SSD-13166280, BLIND CREEK SOLAR FARM, LOT: 17 DP: 535180, LOT: 1 DP: 456698, TARAGO ROAD

Transport for NSW (TfNSW) refers to the notification received on 3 June 2022 for the request for input into the EIS for the abovementioned State Significant Development (SSD).

TfNSW has completed a review of the information provided, including the Traffic Impact Assessment (prepared by Amber Traffic and Transport Direction dated 12 April 2022) and focusing on the impact on the State Road network.

### Proposed Intersection Design

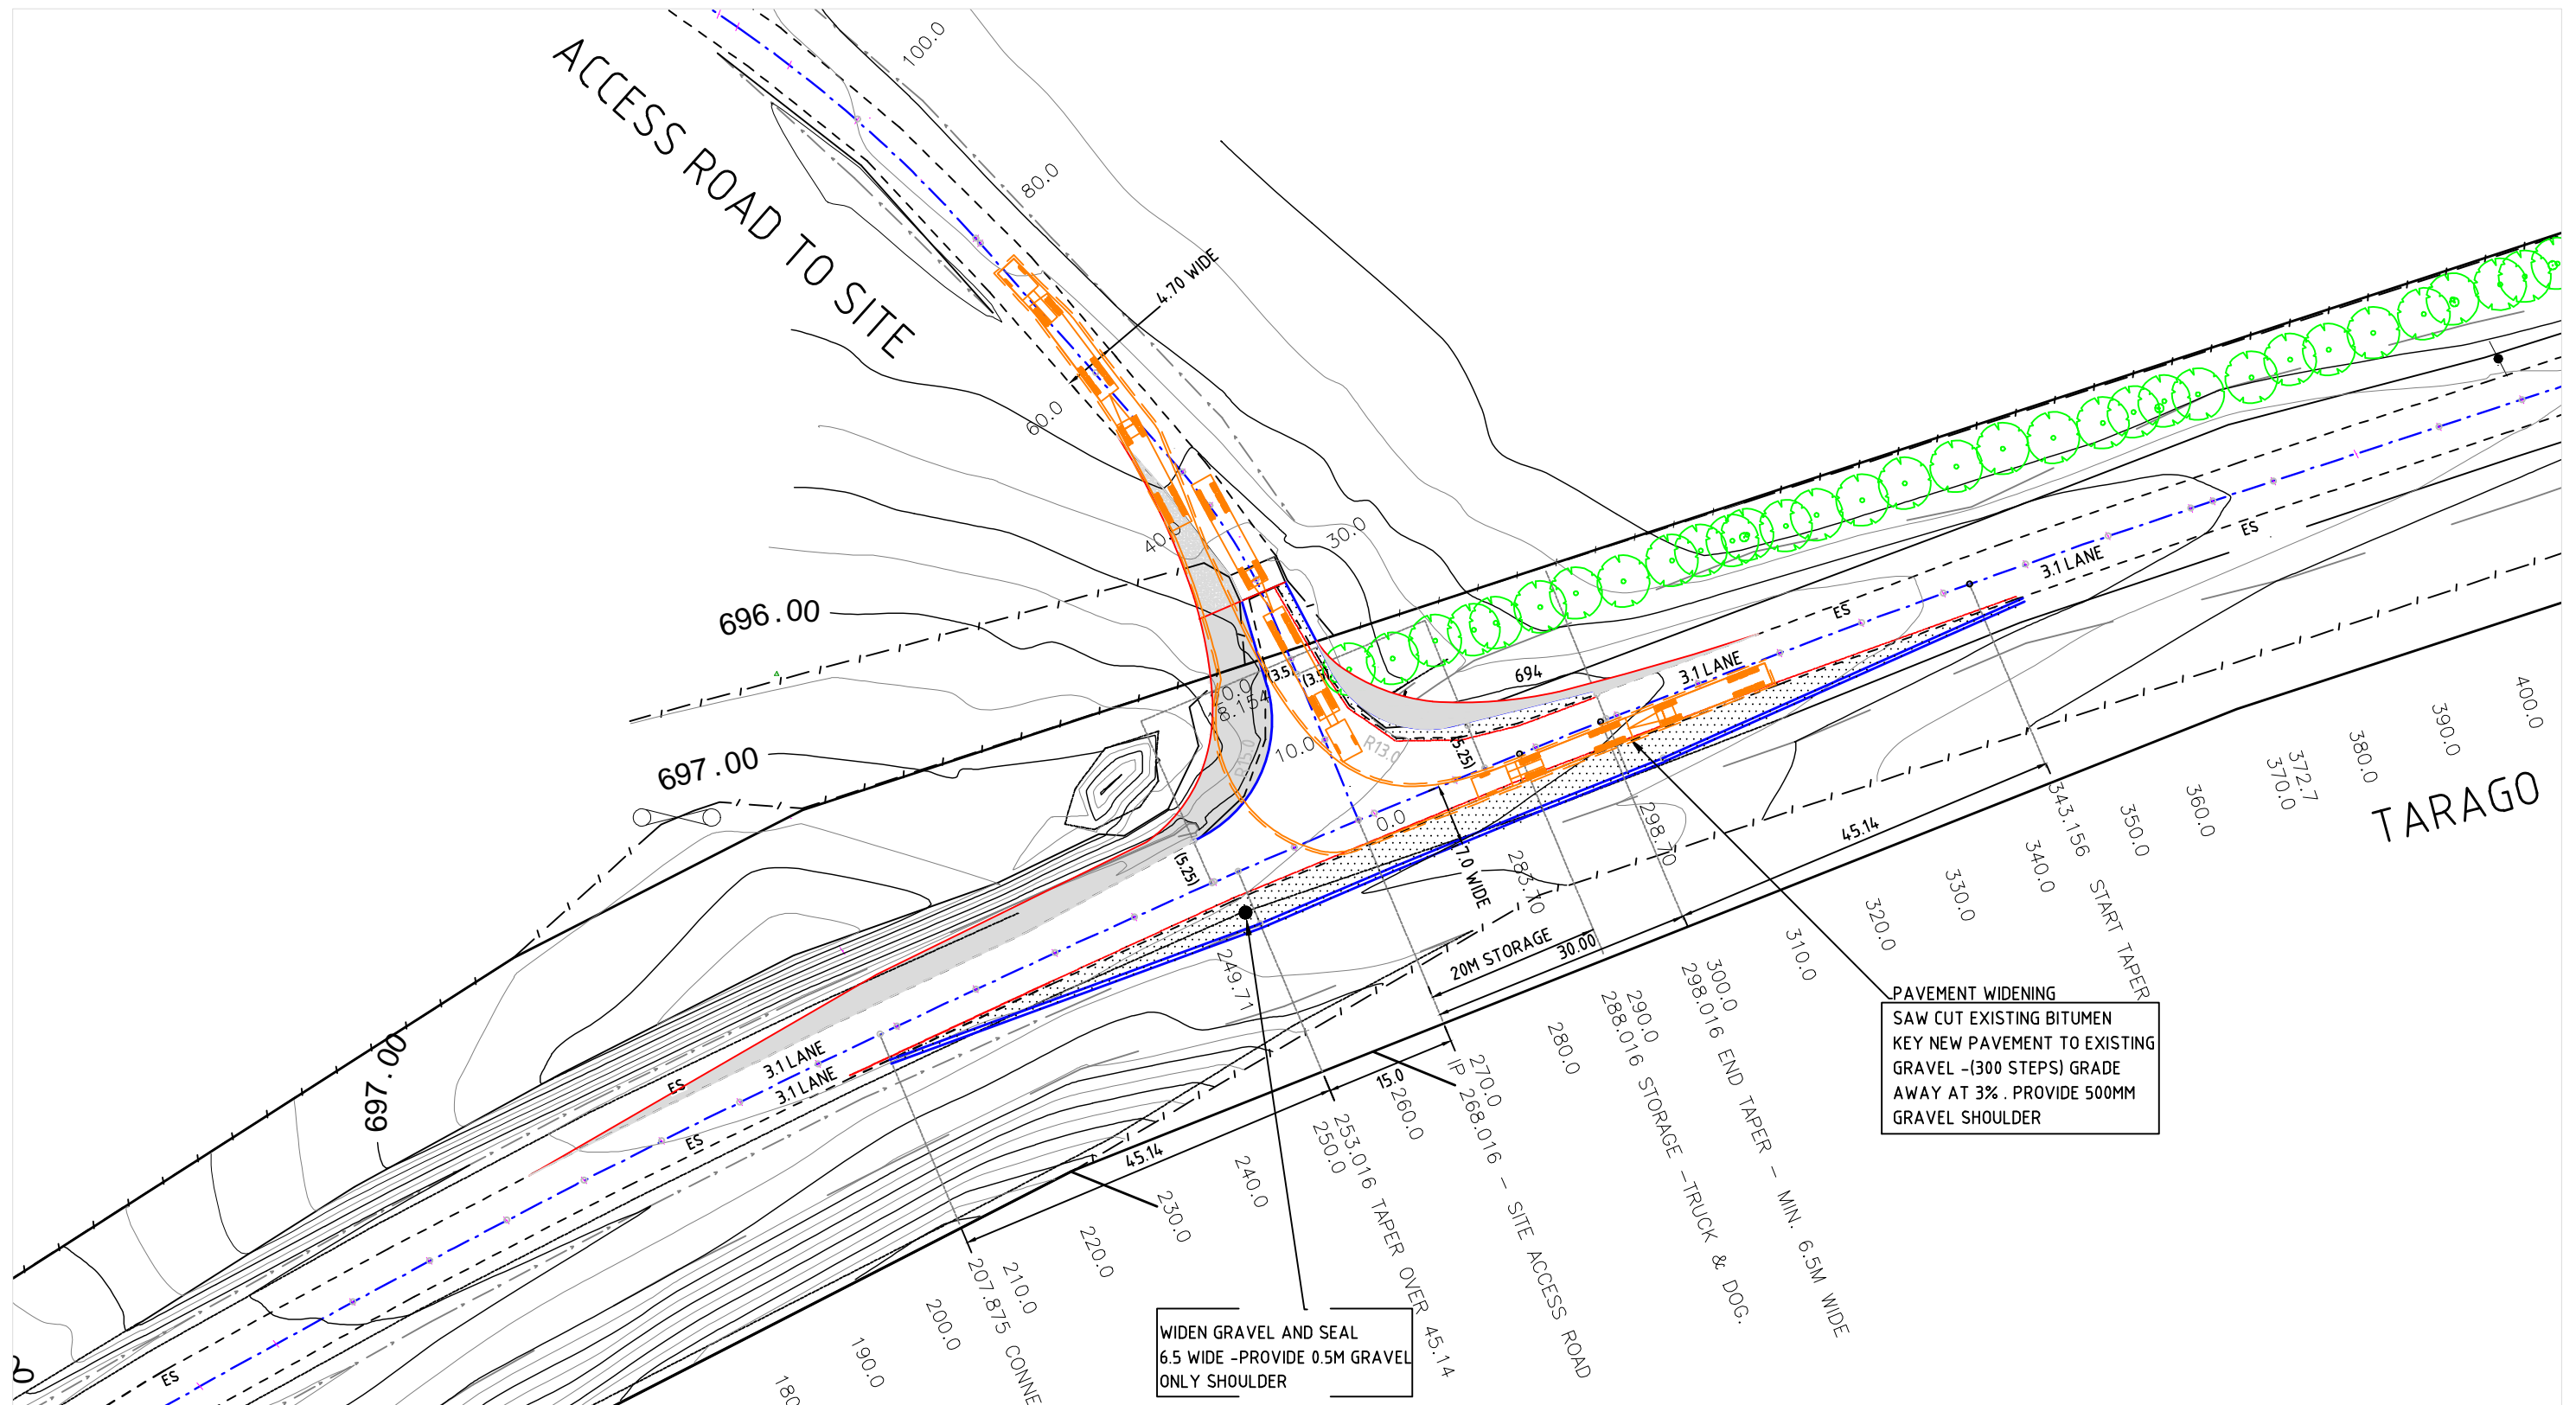
- The length of the BAR treatment should be extended to comply with Figure A 28 of Austroads Guide to Road Design Part 4. The length for the turning path (X) should be added and the tapers should be designed for a design speed of 110kph.
- The table drains on both sides of Tarago Road will have to be reinstated. Cross sections will be required to confirm the roadworks can be contained within the road reserve.
- TfNSW notes only the section shown in Attachment 3 is approved as a B-double route but the intention is to use B-doubles during construction and deliveries. Clarification is required as to how the applicant intends to utilise B-doubles noting the above.
